# ENG-SF21021-R1-CD-GEC.pdf Markup Summary

STREET IMPROVEMENT PLANS

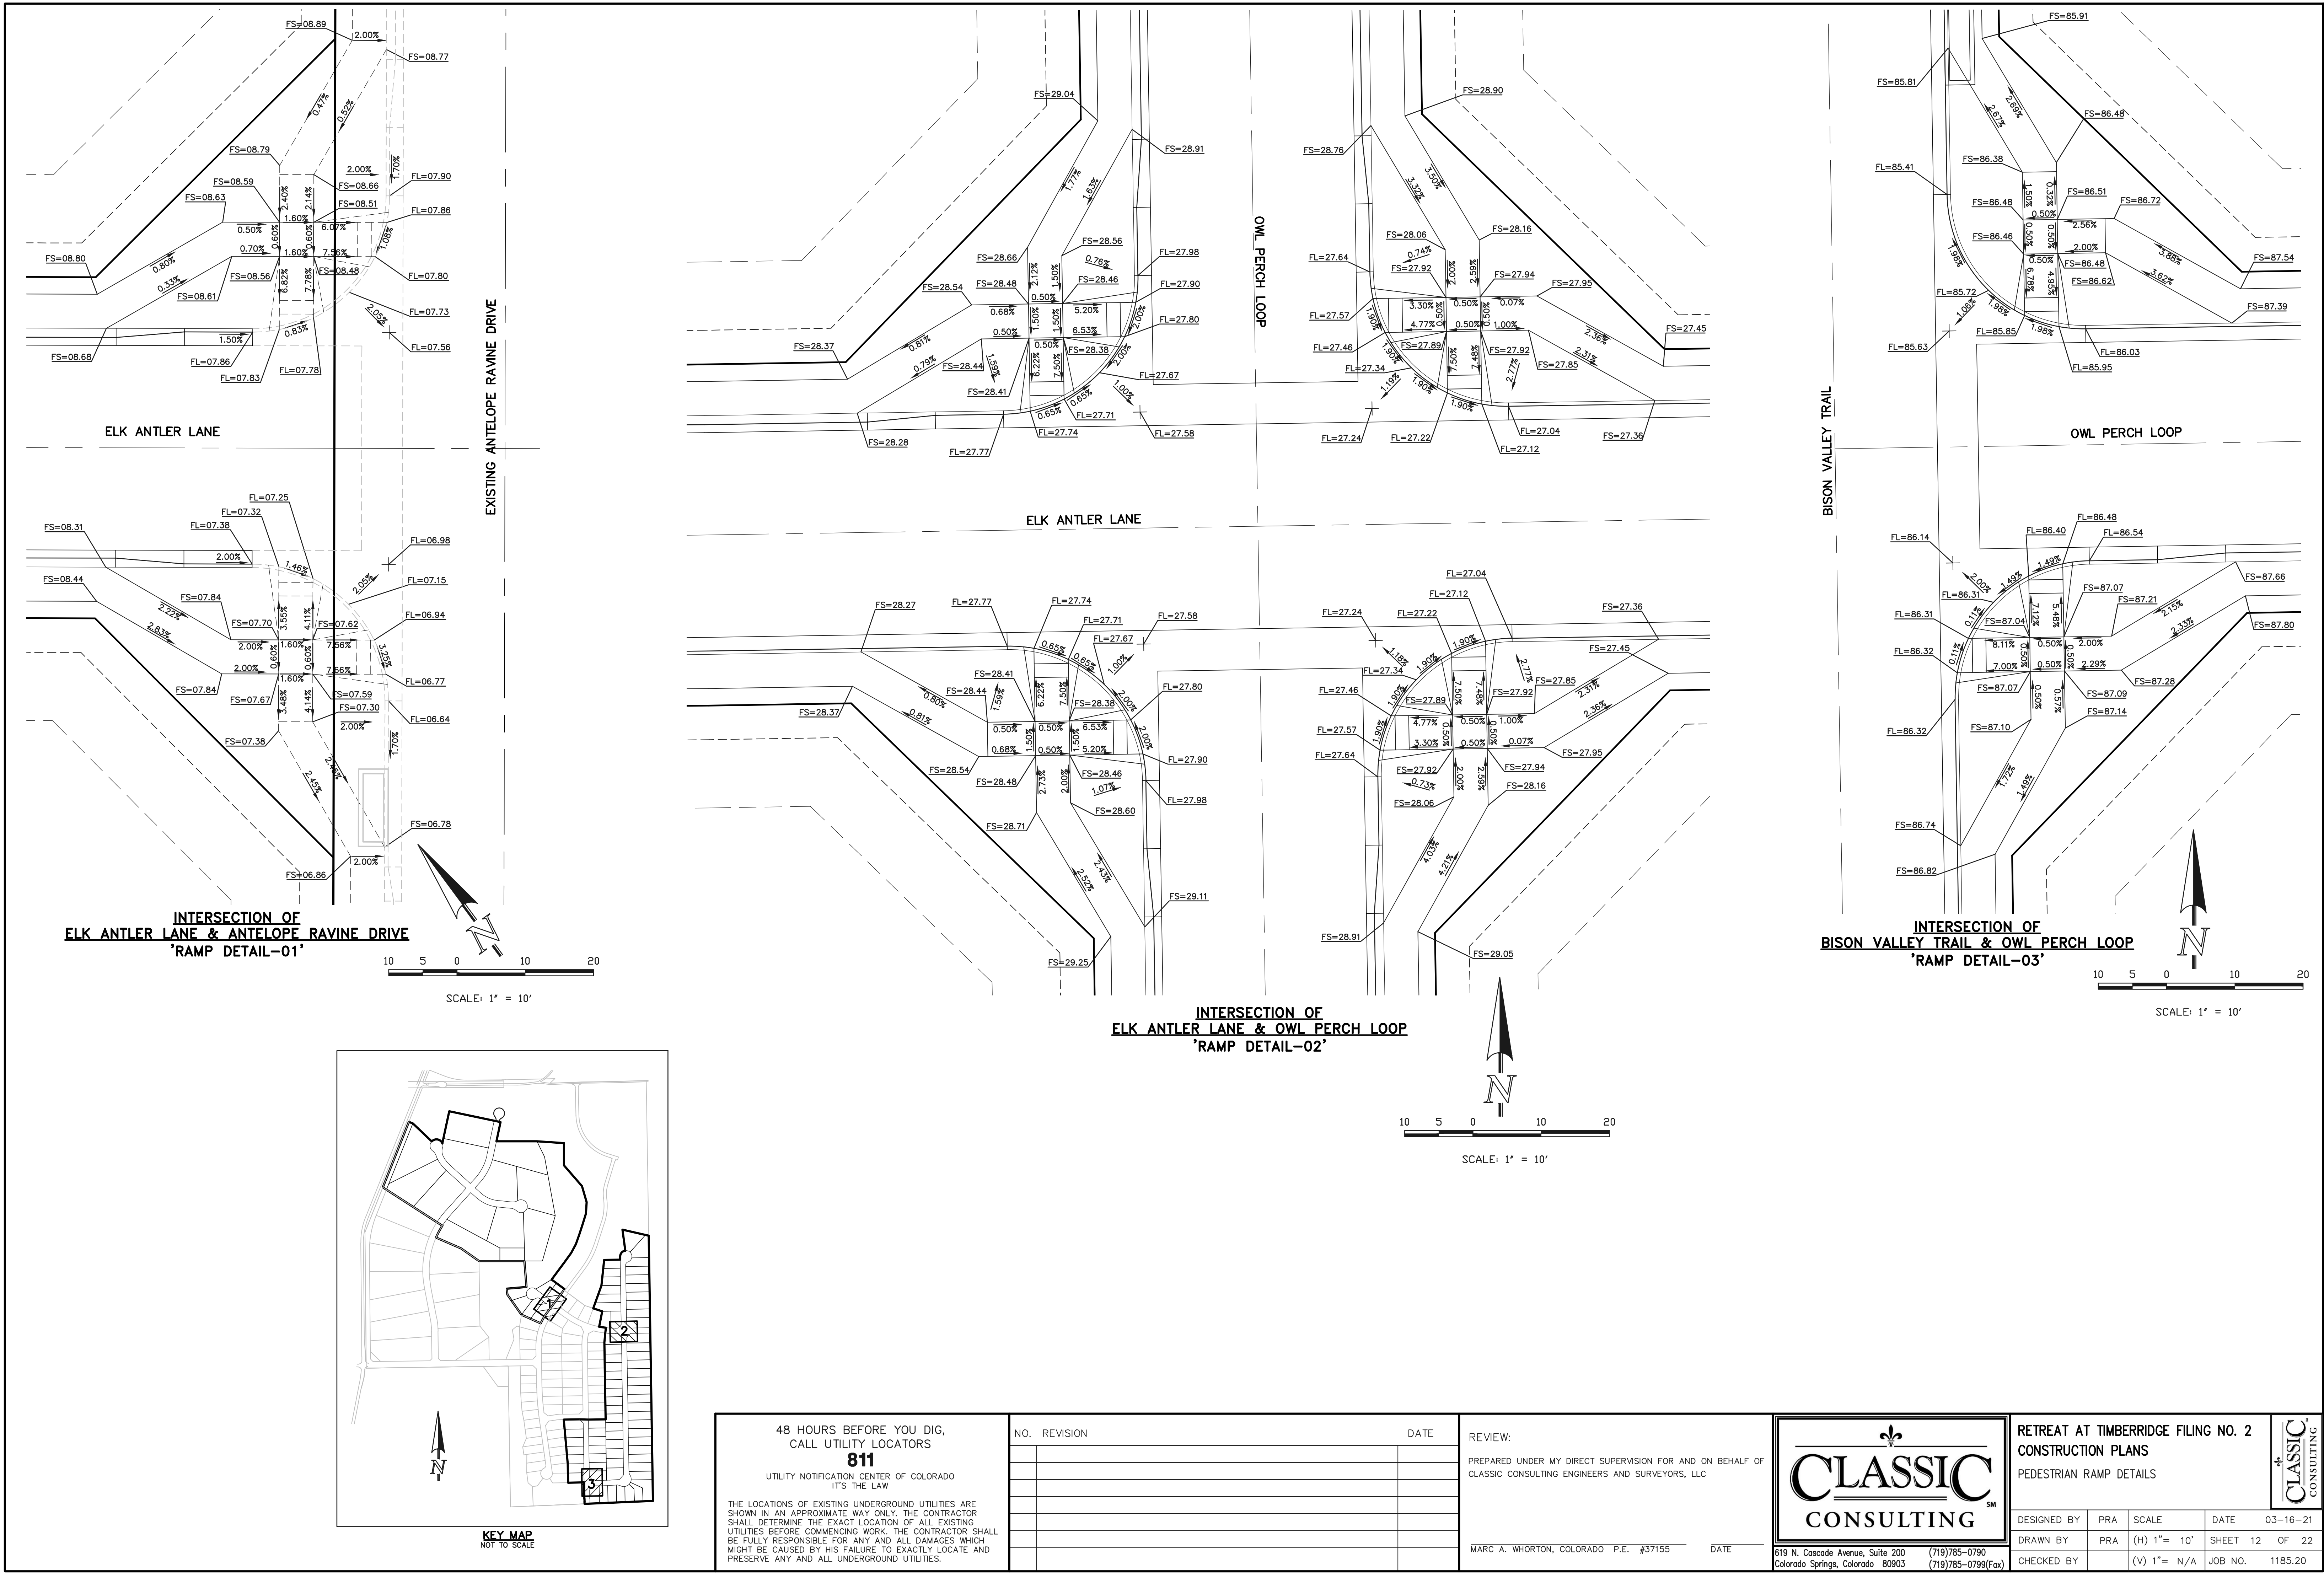
Add curb chase for overflows from inlets?

show and label barricades here

See FDR comments regarding downstream conveyance. Show on the GEC plan.

DESIGNED BY	PRA	SCALE	DATE	02-25-21																																														
DRAWN BY	PRA	(H) 1" = 50'	SHEET	14 OF 22																																														
CHECKED BY	(V) 1" = 5'	JOB NO.	1185.20

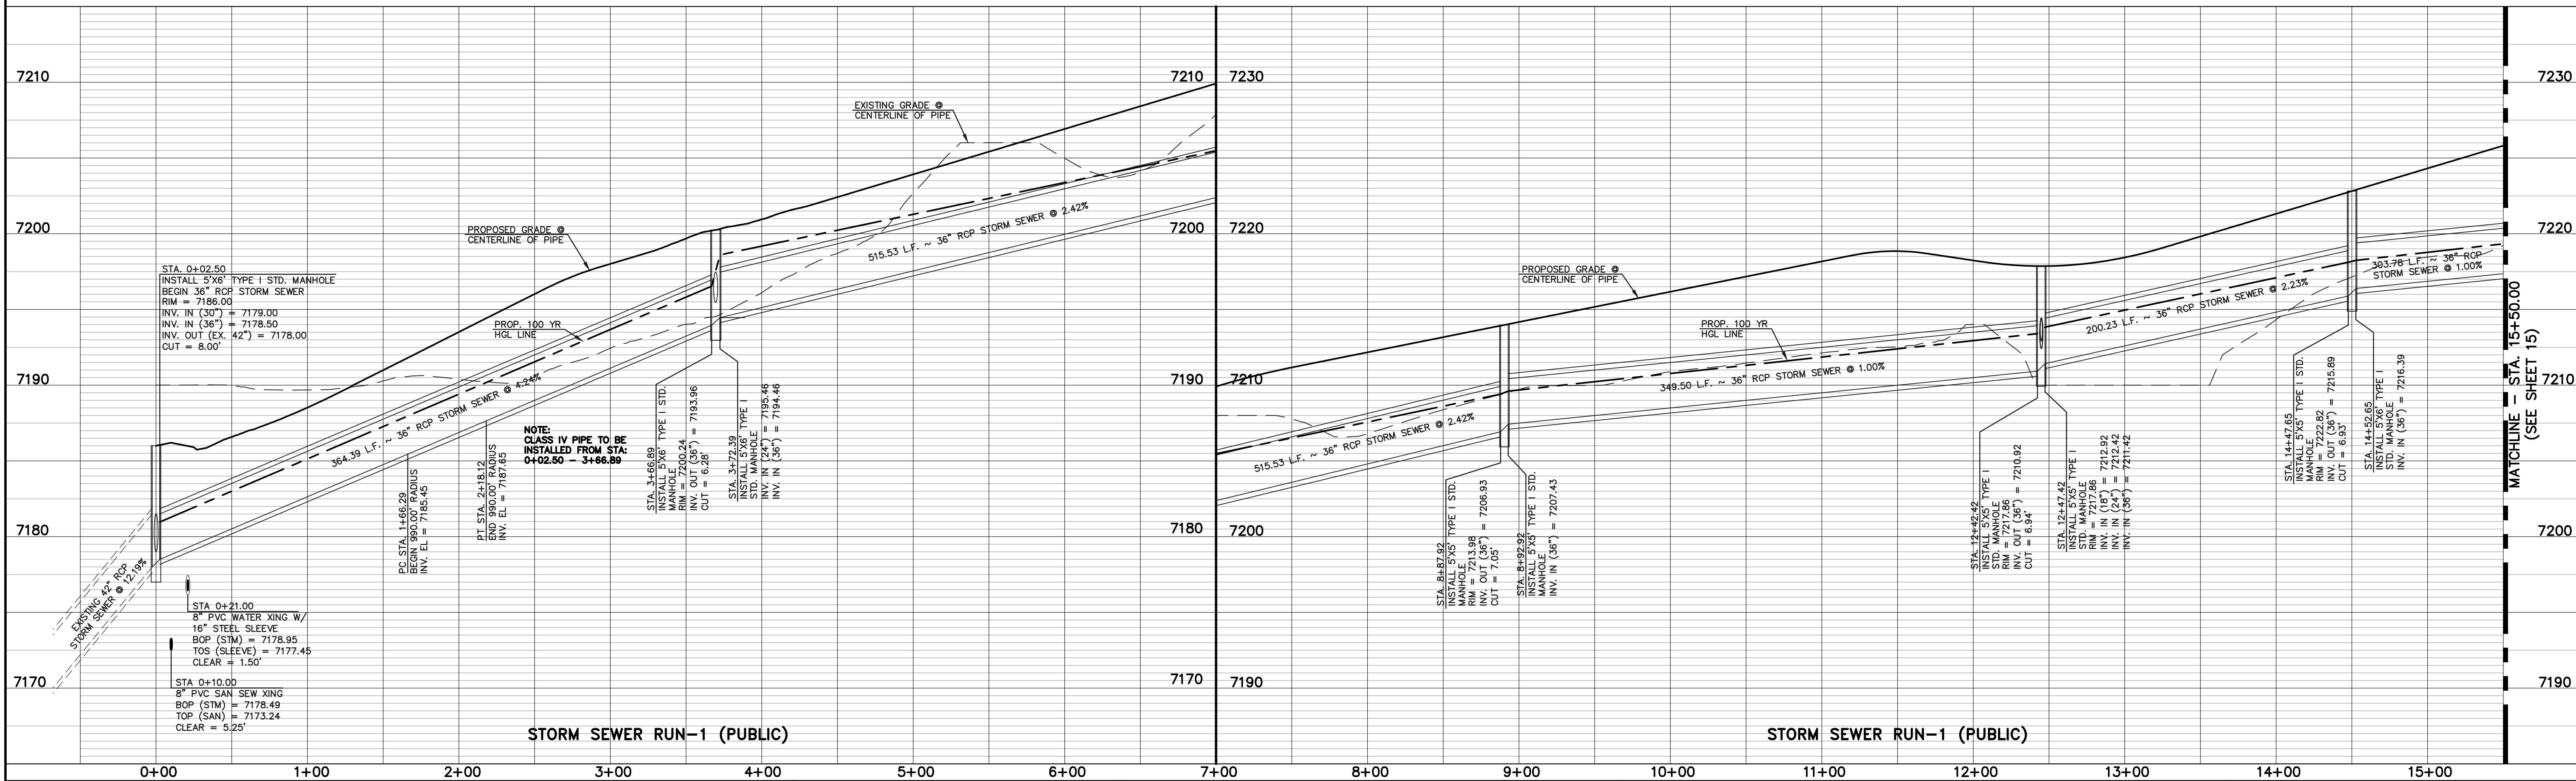
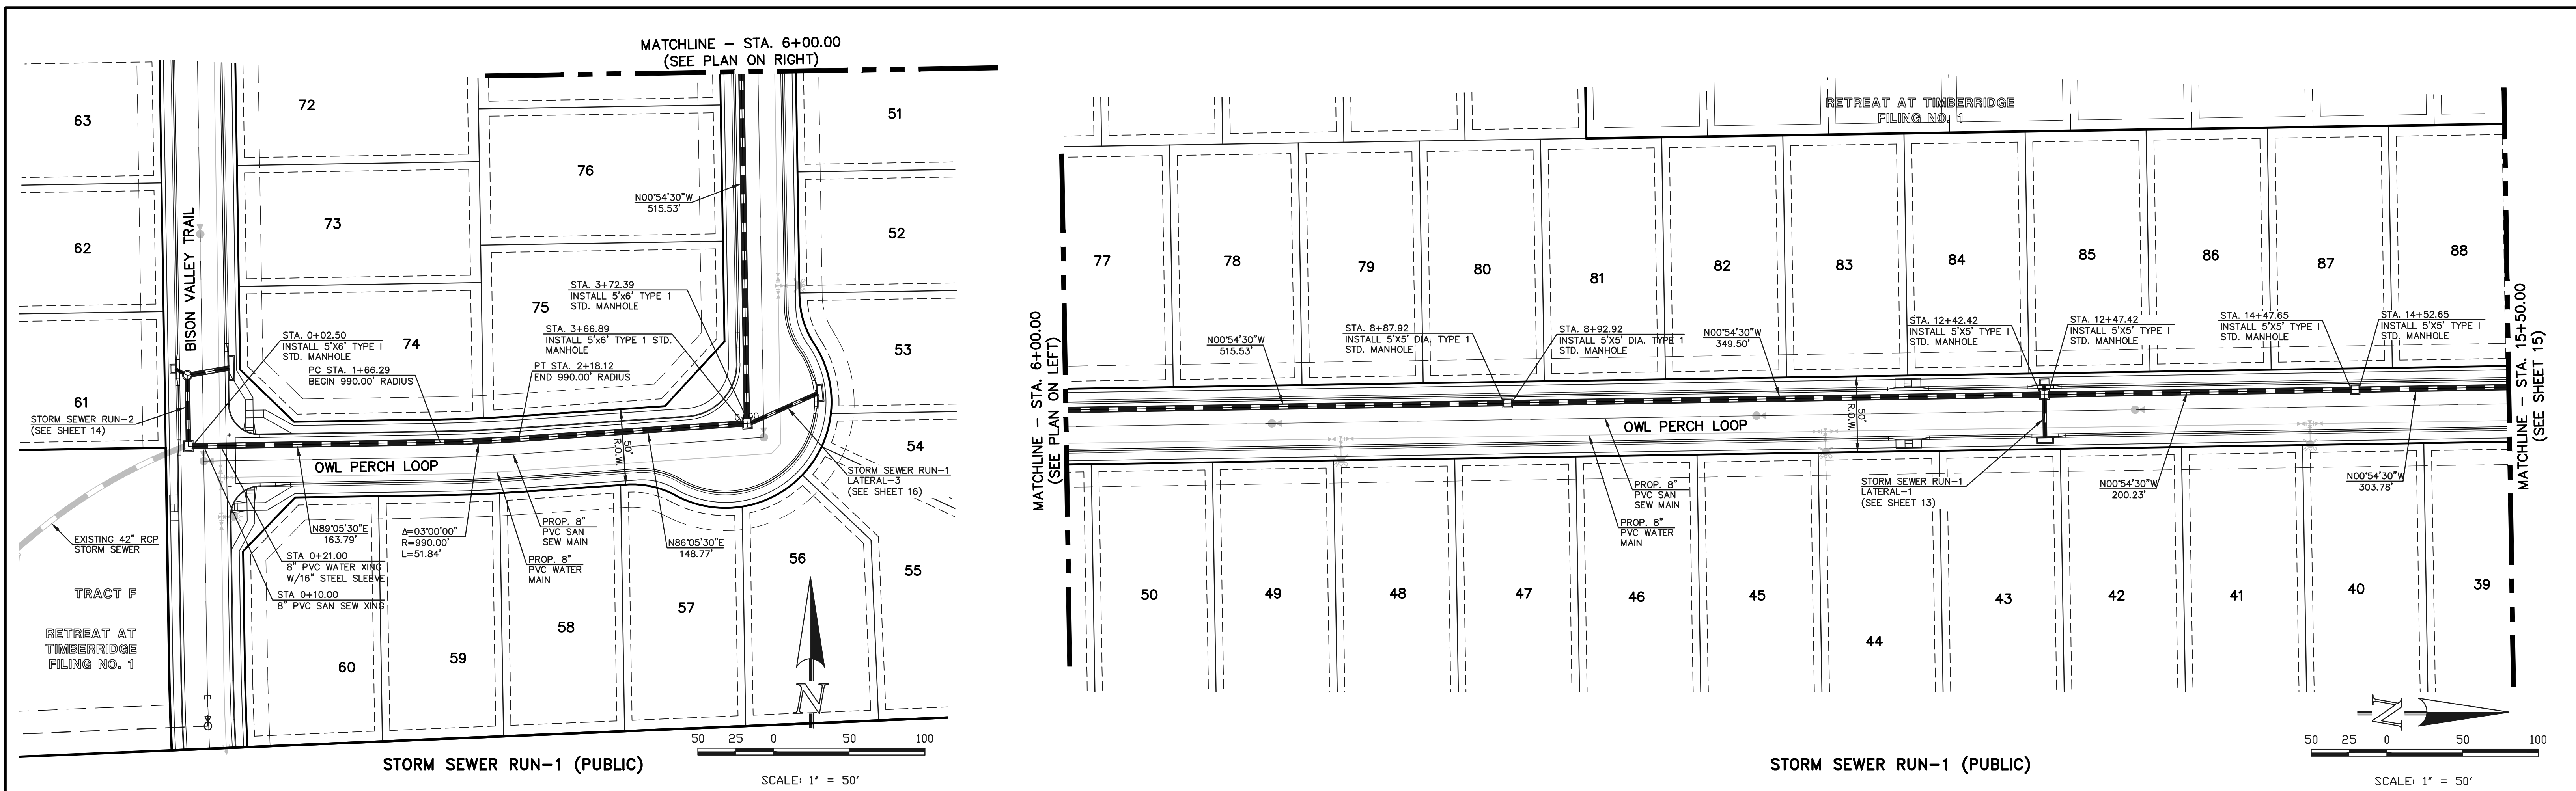
Watertight joints ?
